SSD-32275057 – Redfern Mixed Use Co-living Development – Advice on EIS

Thank you for your correspondence dated 1 November 2022 inviting the City of Sydney Council ("the City") to comment on the proposed State Significant Development (SSD) application for a new co-living housing development at 175-177 Cleveland Street, 1-5 and 6-8 Woodburn Street, Redfern.

LEVEL 2
1:500

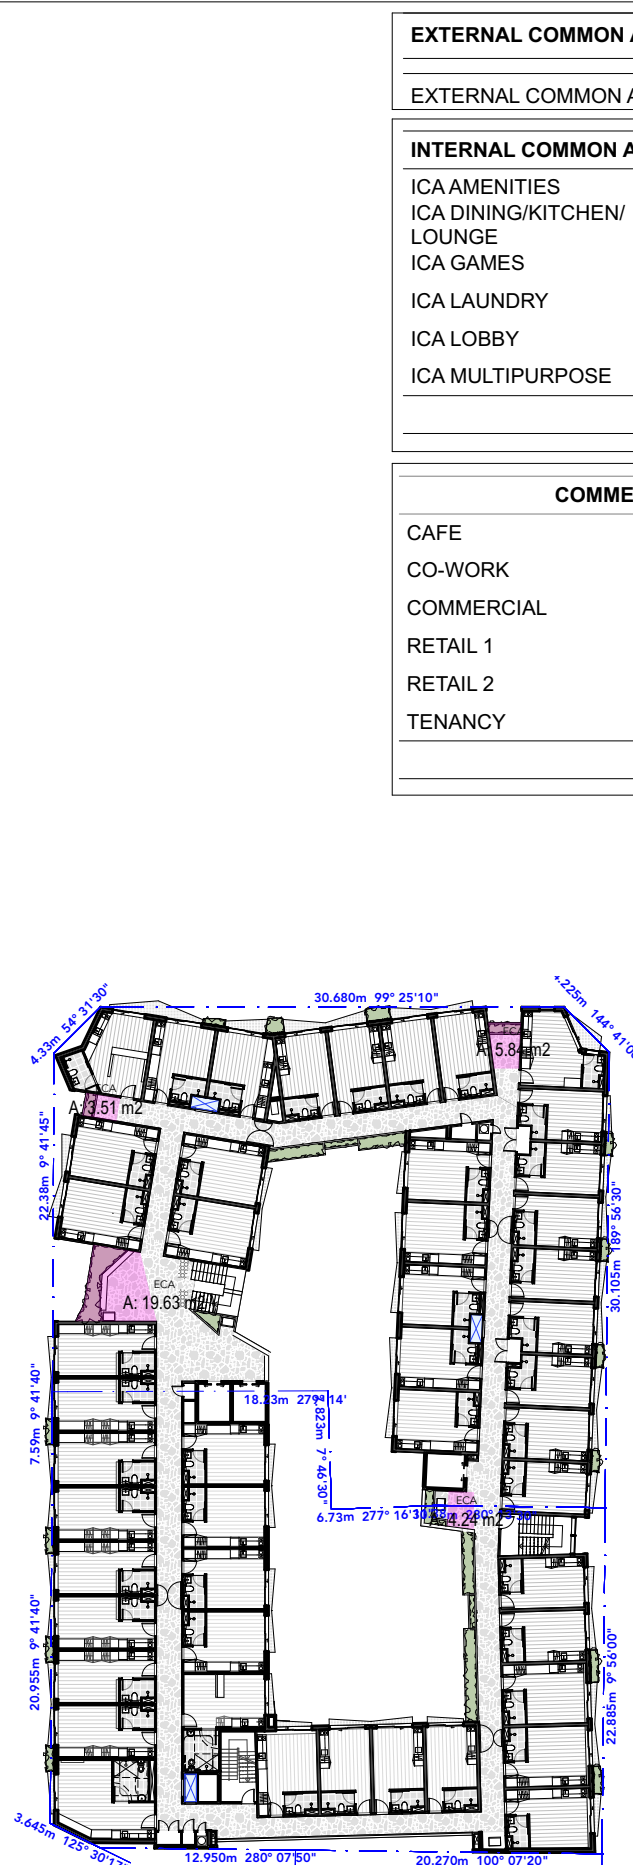
Room type E4 has inadequate circulation for residents to get into their bed.

- Room type E4 (double room) is to be redesigned to provide adequate circulation for residents to get into their bed.

1 TYPICAL PLAN - NATURAL CROSS FLOW VENTILATION PATH
1:100

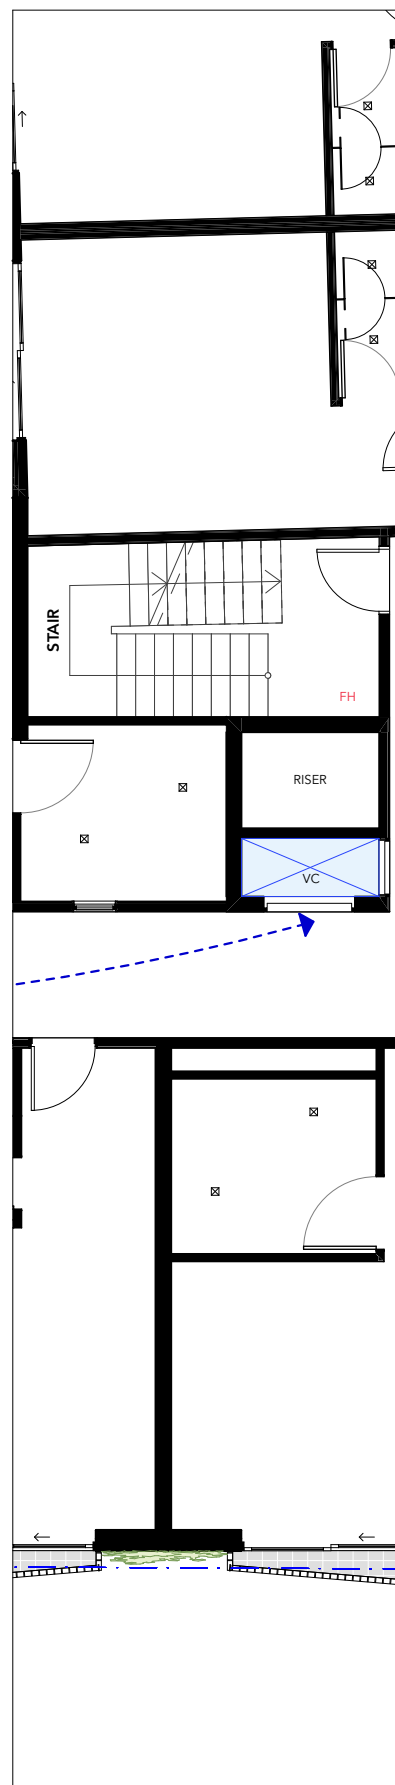
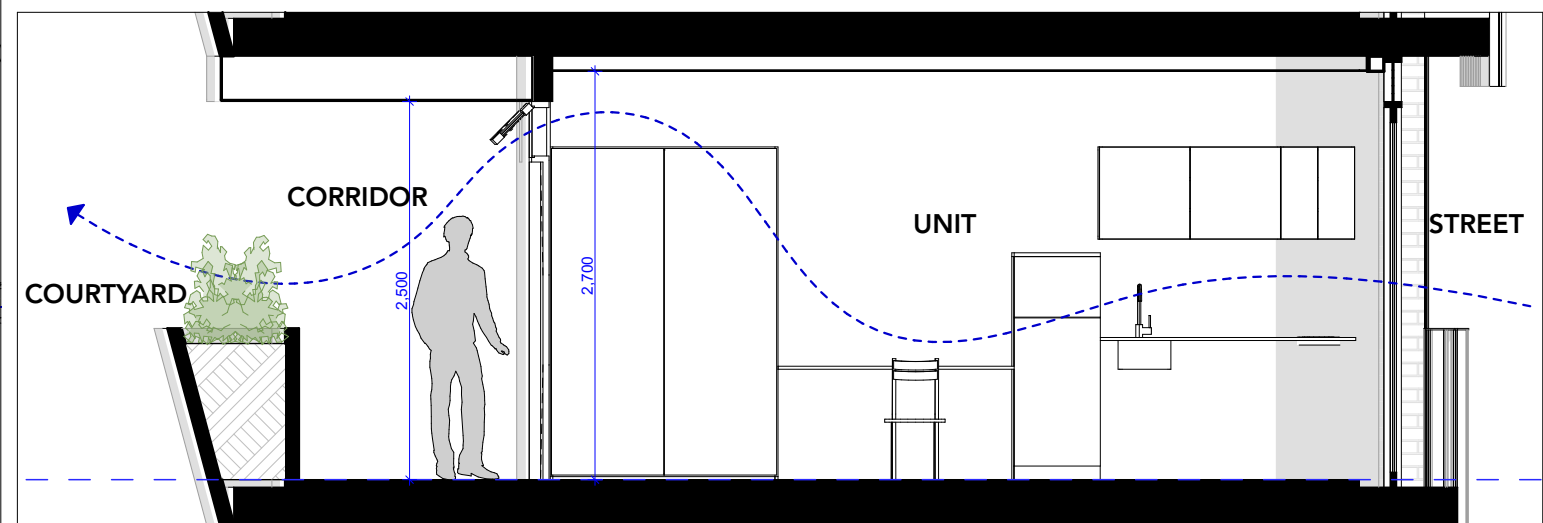
No details are provided regarding how noise affected facades are to achieve both acoustic attenuation and natural ventilation simultaneously.

- The alternative attenuated ventilation strategies required to all facades facing Cleveland Street and Woodburn Street (as stated in the submitted acoustic report) needs to be fully detailed to those noise affected facades to ensure adequate ventilation amenity. Currently what is provided does not confirm this being achieved.
